Permit Number: 060283

This is to certify that MCGINNIS ERIC F/Homeowner
has permission to Amend permit # 04-1606 provide stairs from 1st to 2nd Depot
AT 29 EASTLAWN RD L 338 J002001

Proposed Project Description:
Amend permit # 04-1606 premade stairs from Home Depot

Back Steps - Side View

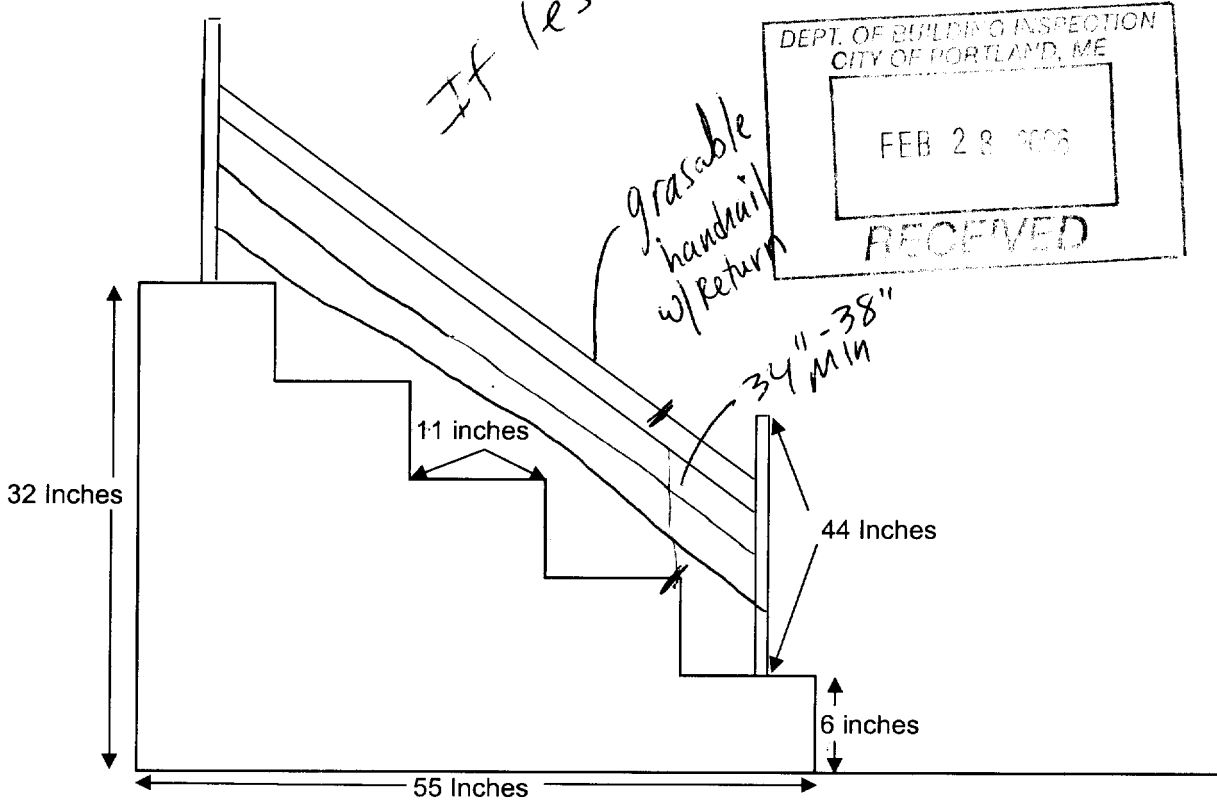
- Guard is only on one side (33" off grade)
- NO graspable handrail
- W/posts and rails width is too narrow
will be less than 31"
- There is no nosing
- Not 10" net

03/27/2006-jmb: Spoke w/Eric M About stair details as noted on plans, ok to issue
